February 5, 2014

**RE: Winrock Town Center Drainage Master Plan (J19/D058)  
Response to Comments**

Proj. file: 2031 SD BASIN 100-proposed.stm

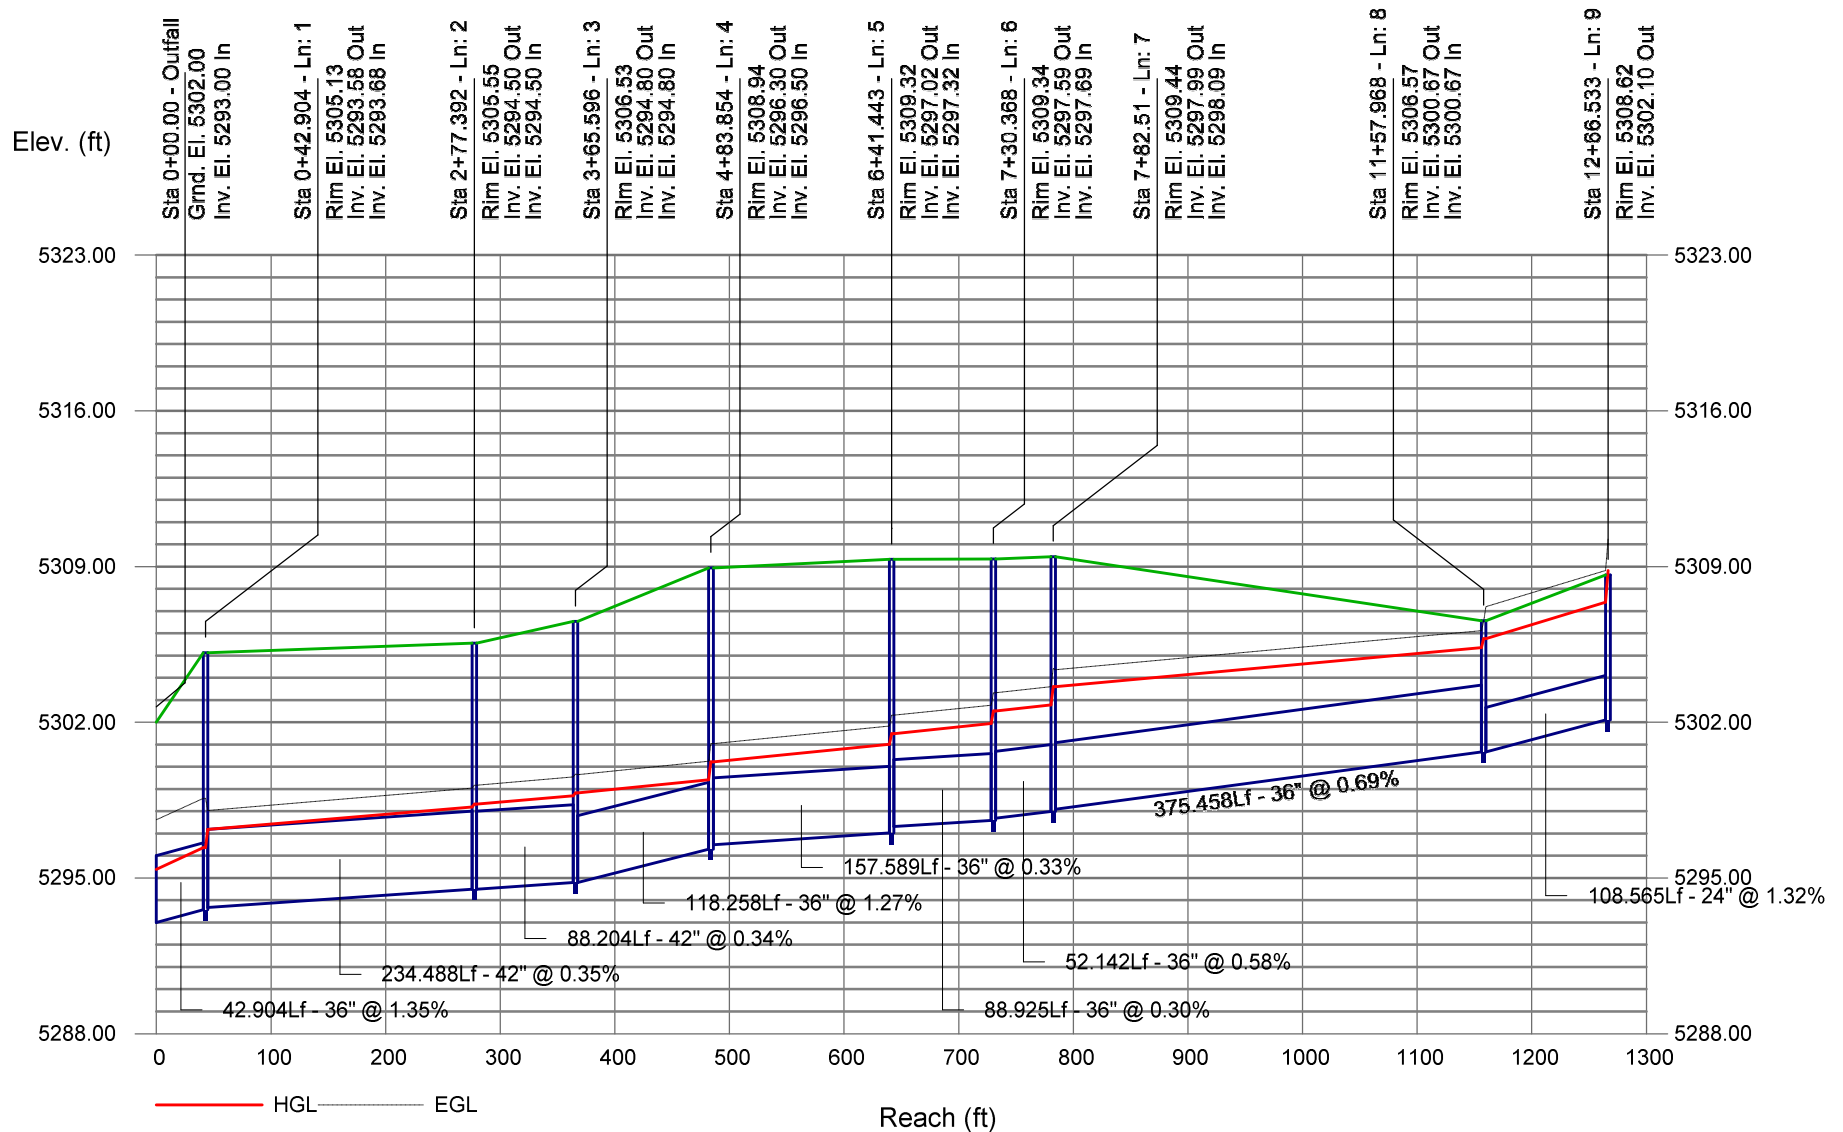
- C. In the Table (in three locations) and on the Basin Map, the Basin 100 discharge size is labeled as 24 inch. Previous reports describe this as 36 inch. Please revise.*

Done.

WINROCK TOWN CENTER-BASIN 300

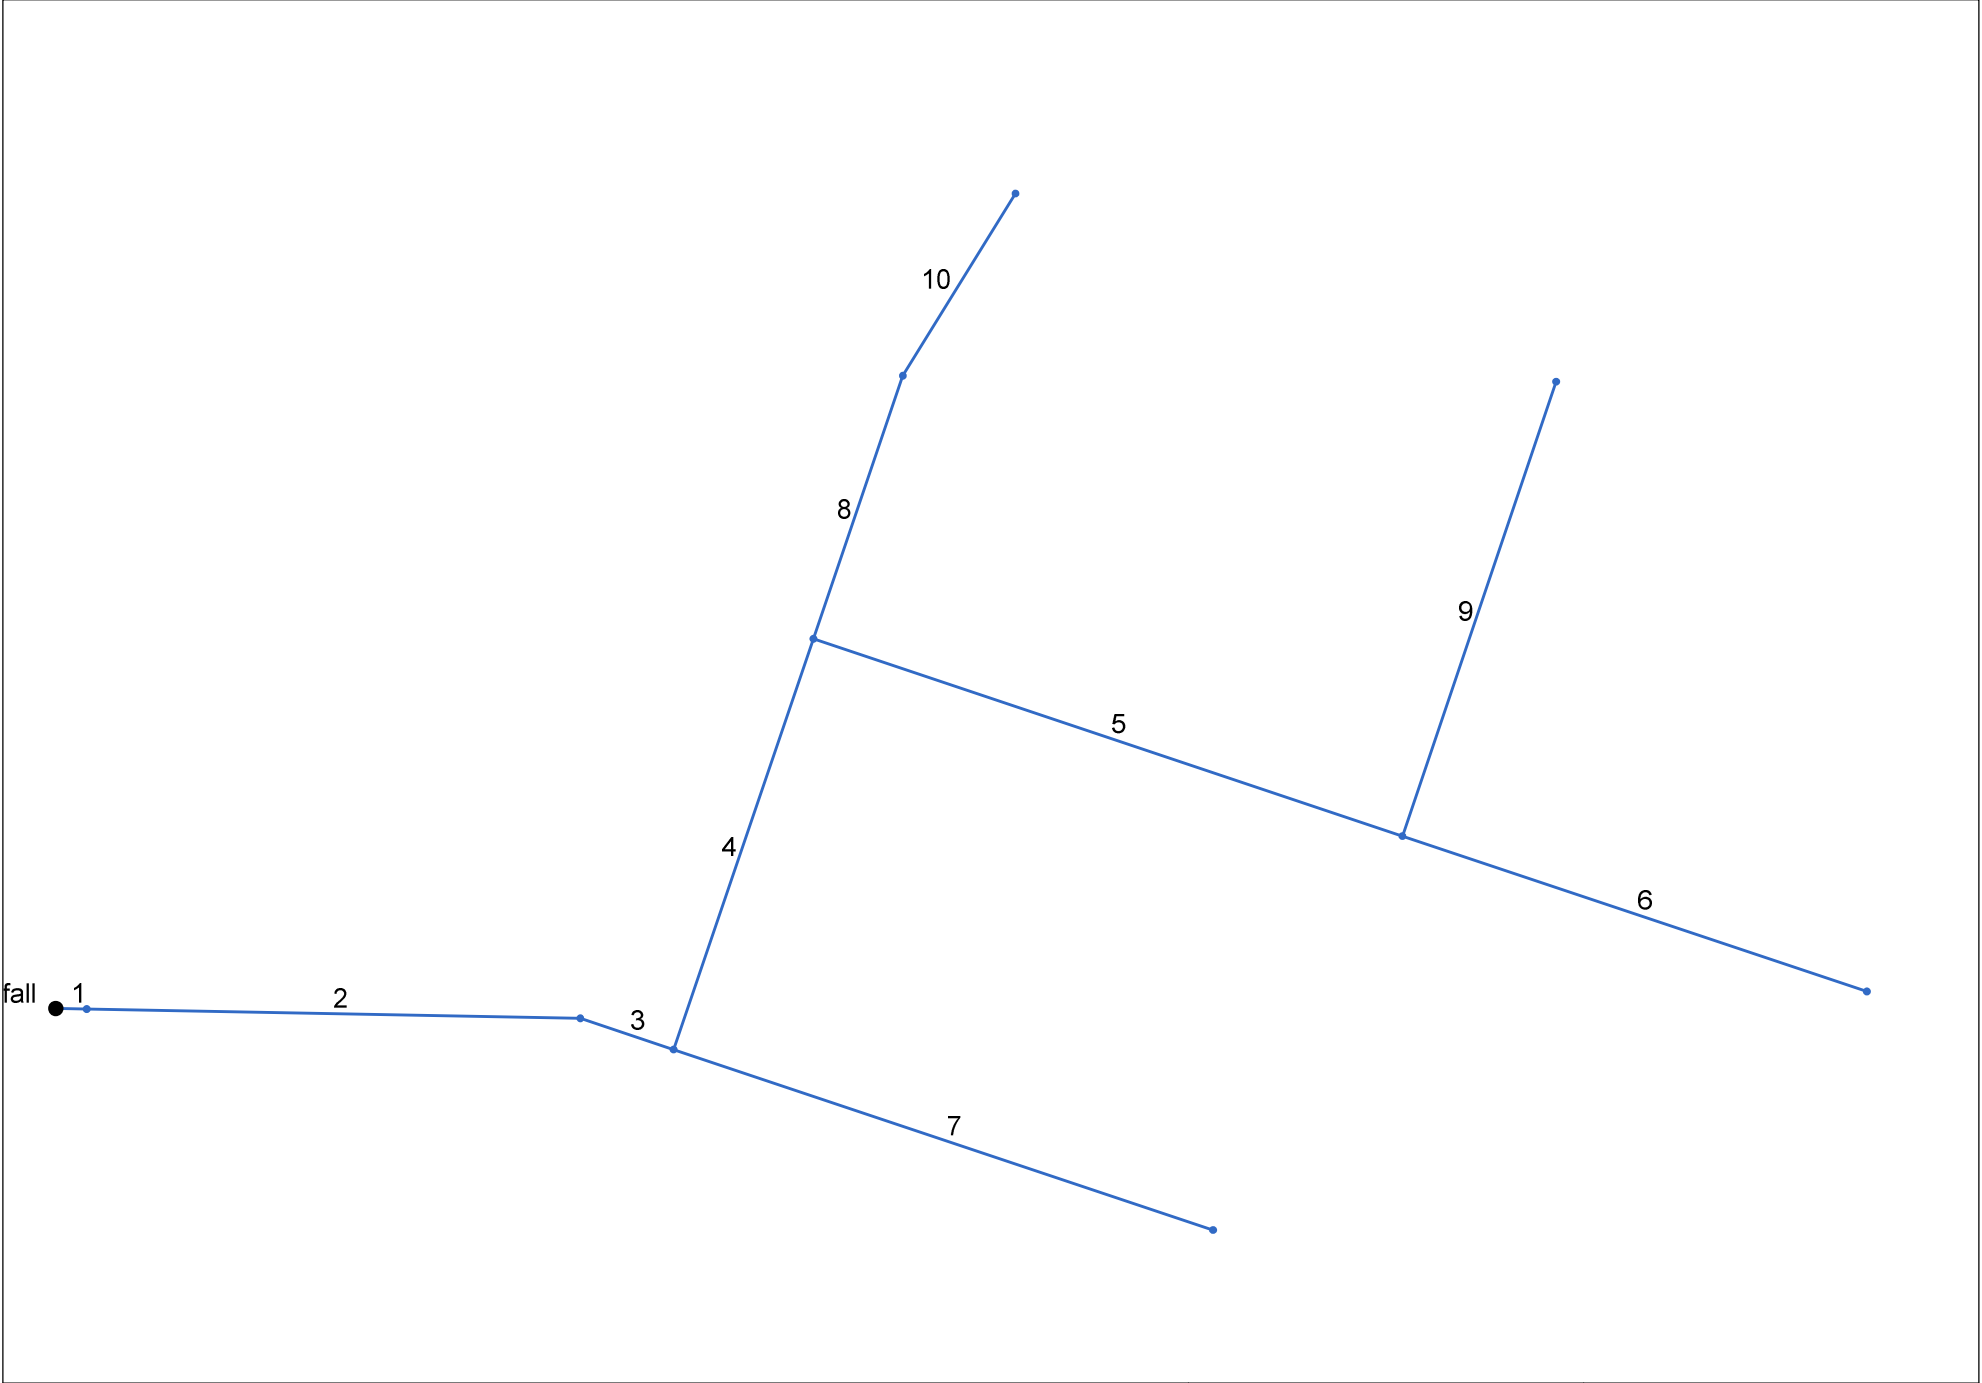
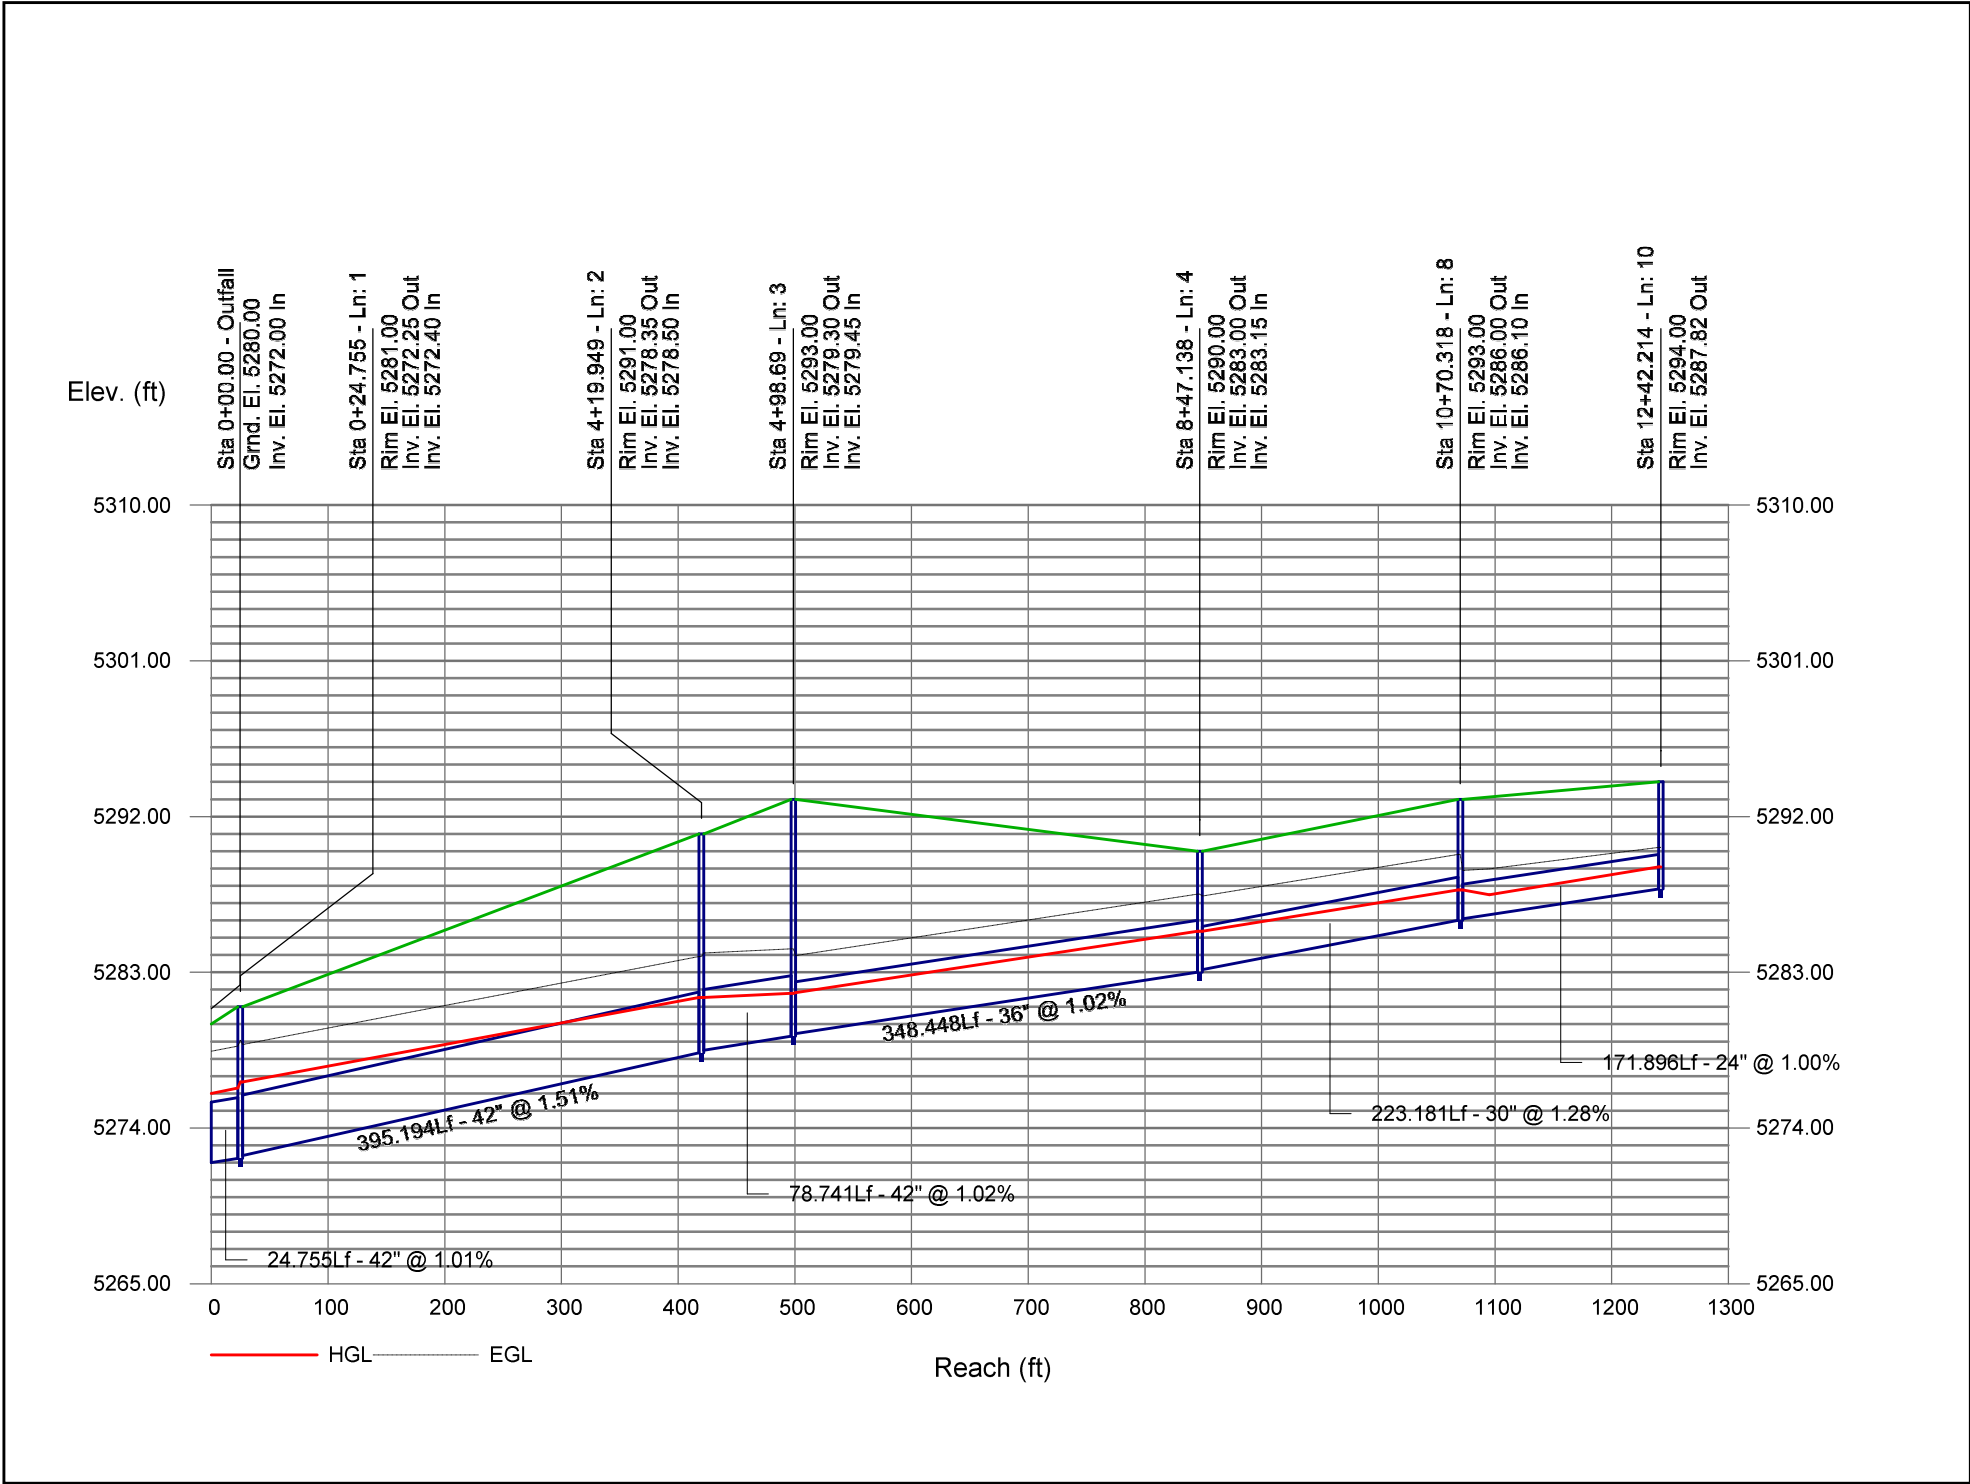
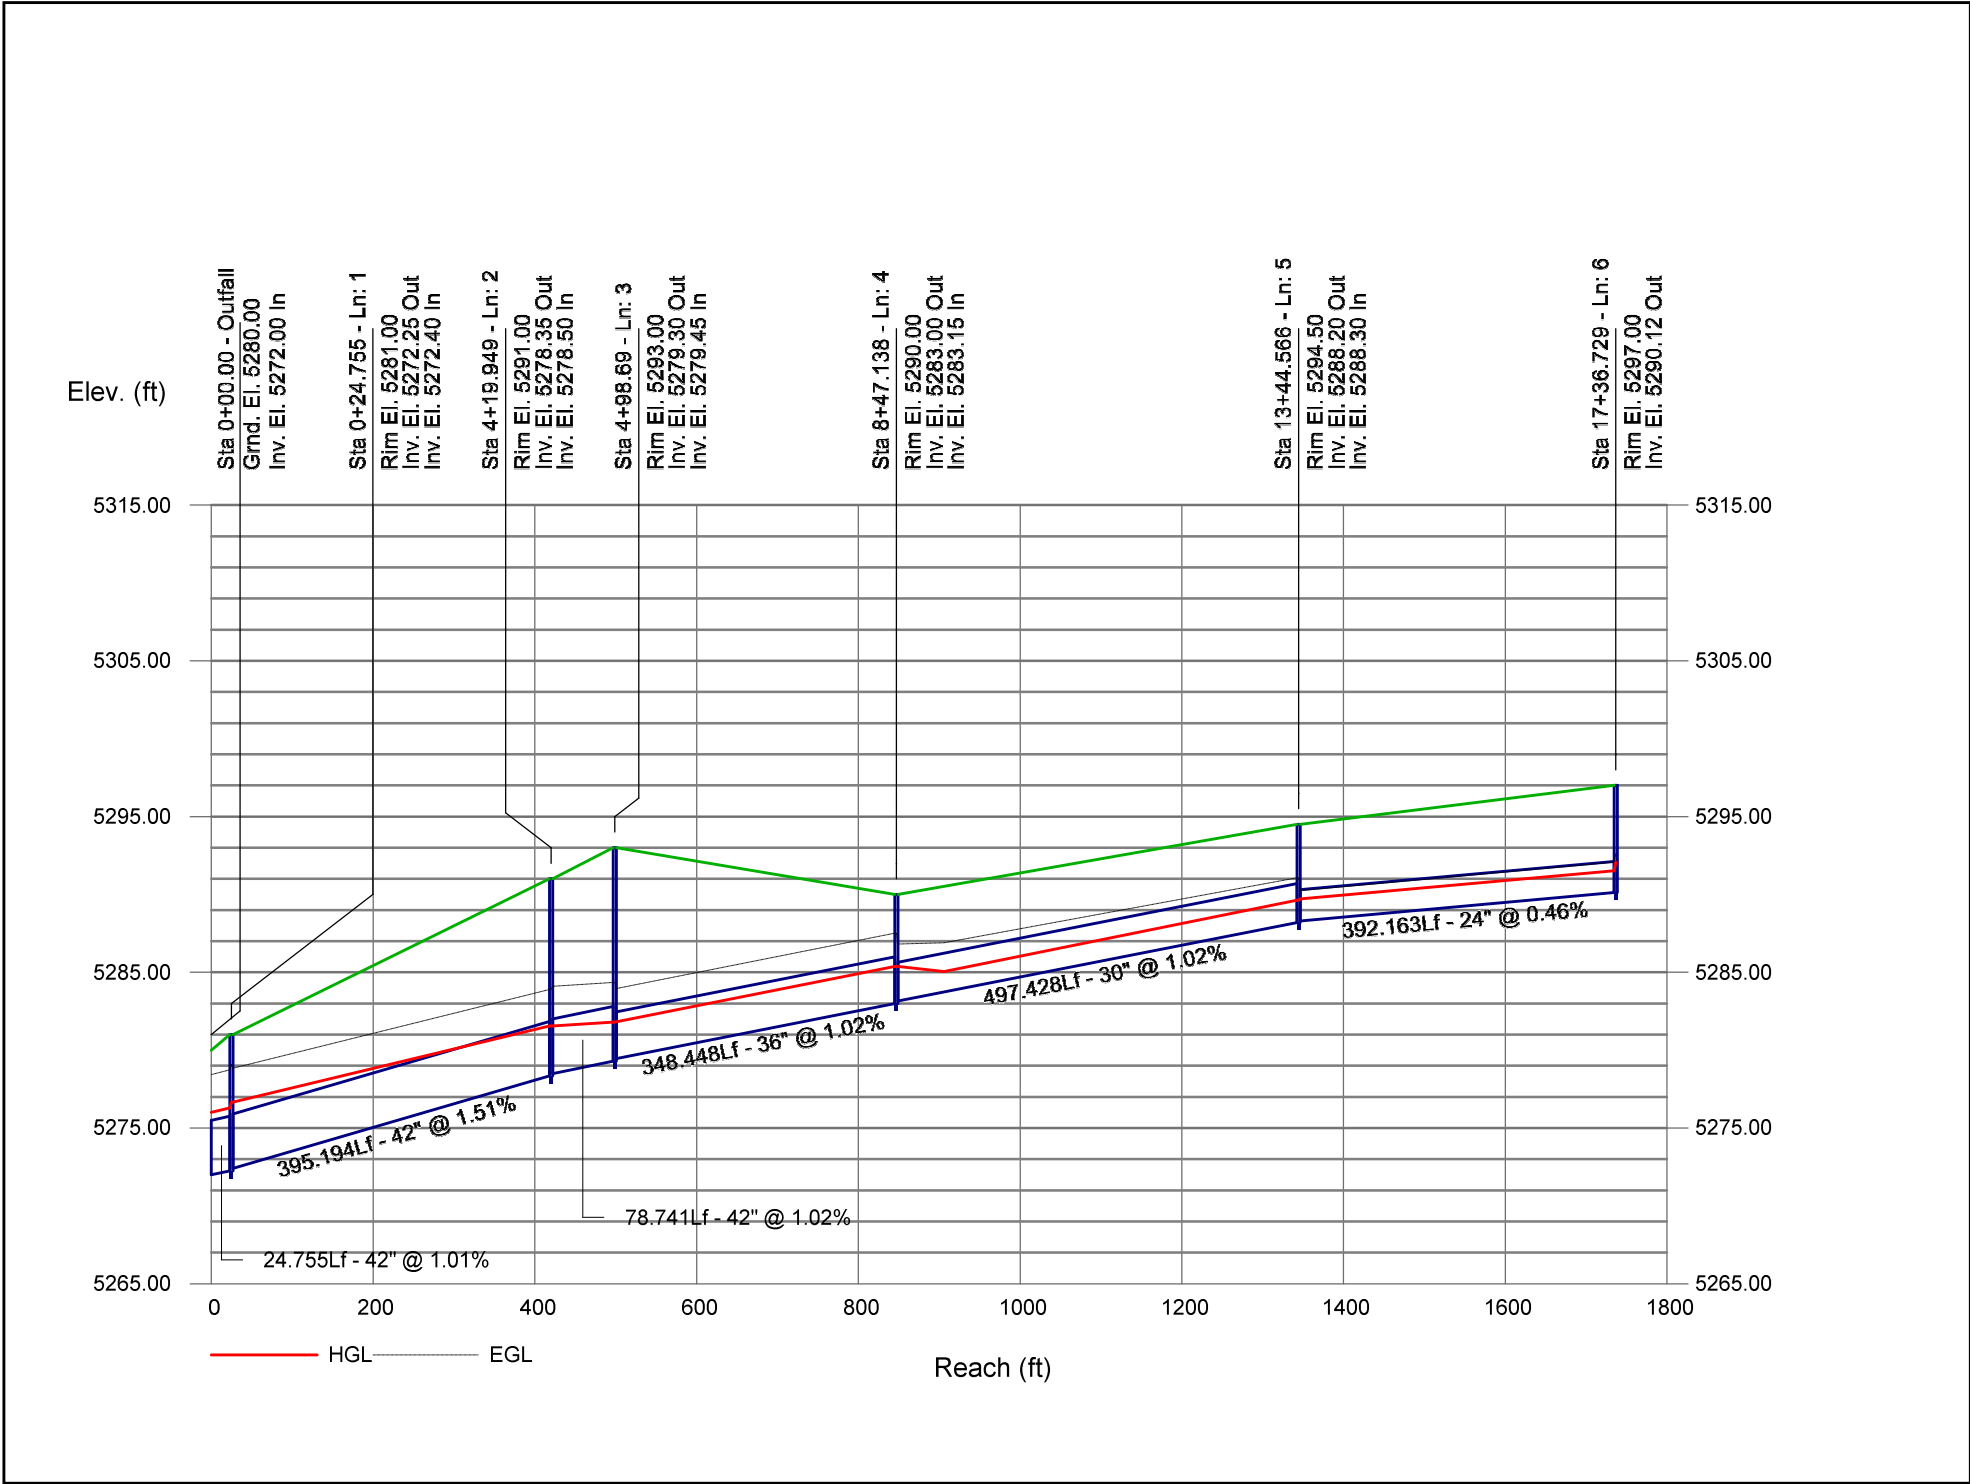
- A. For Basin 300, the flow in the Table is 120.3 cfs. The maximum flow for Basin 300 in Appendix C, Storm Drain Calculations is 81.40 cfs. Which is correct? Revise accordingly.*

The correct flow is 120.2 cfs. The discharge from the H-Z Amendment is 120.4 cfs. It is slightly lower in this revision than in the reviewed DMP because the basin lines shifted some to allow the existing storm drains to handle all of the flows. The storm drain calculations now have matching total flows.
